Highways and Transportation

Date: 17 November 2020

Application - SE/19/05000/HYB

Location - DSTL Fort Halstead Crow Drive Halstead Sevenoaks KENT TN14 7BU

TECHNICAL NOTE

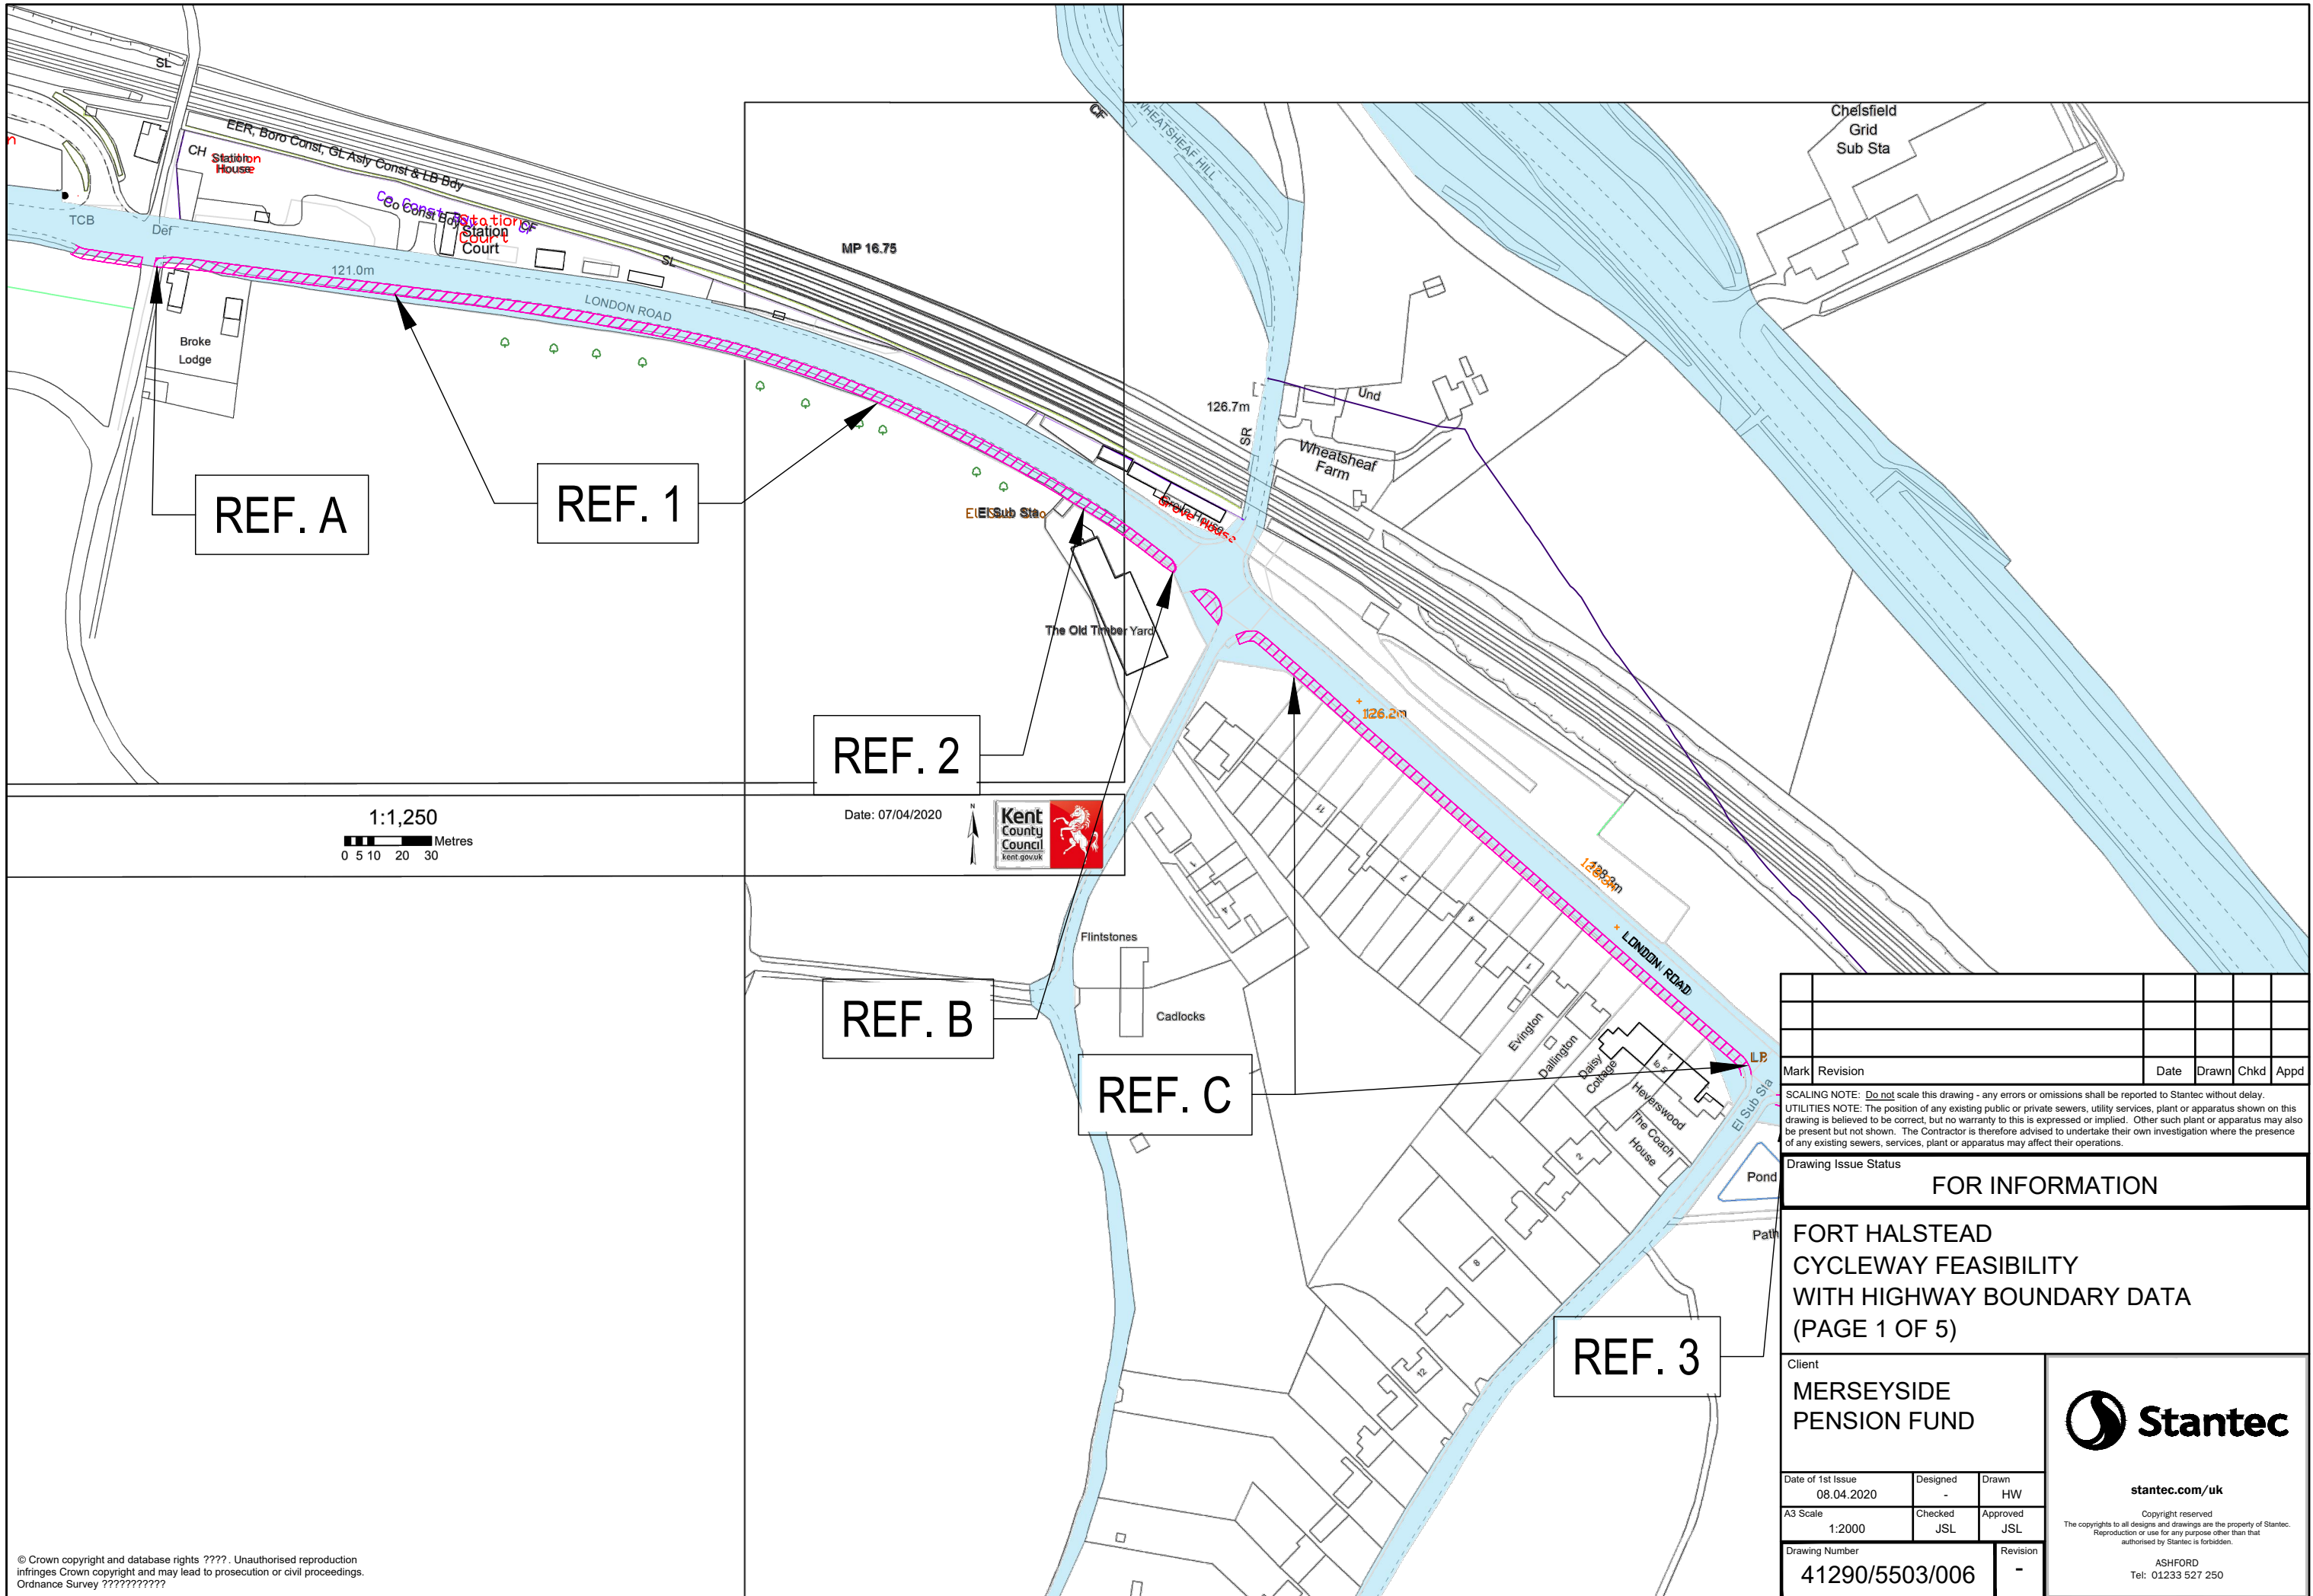
- Existing bridleway between Polehill & Twitton – Lighting improvements at this location are proposed through a S106 contributions.
- London Road linking Otford Lane – provides links to existing on street cycle route at Old London Road, providing access to Knockholt Station – A Technical Note has been submitted to understand the feasibility of providing a 3.5 metres wide (two way) cycle way along the western edge of the carriageway. Several constraints have deemed such a cycle way unsuitable. Alternative measures include ‘Orca’ lane separate devices, but guidance suggests that these are only suitable on low speed roads. The TN suggests that the majority of accidents involving cyclists took place off peak, suggests sports cyclists as opposed to commuters. To make this an attractive cycle route, alternative measures to improve safety need to be investigated.

A TRO to prevent parking would be subject to best endeavours, as a third party application is subject to a public consultation exercise. This is to provide a safer cycle route to the station, as currently cars block the route by parking on the advisory cycle lane.

Stopping cars parking across the cycle route on Old London Road – Double yellow lines may be implemented along sections of Old London Road to ensure the cycle route is kept clear from parked cars. This matter would be dealt with through a TRO process following grant of planning permission.
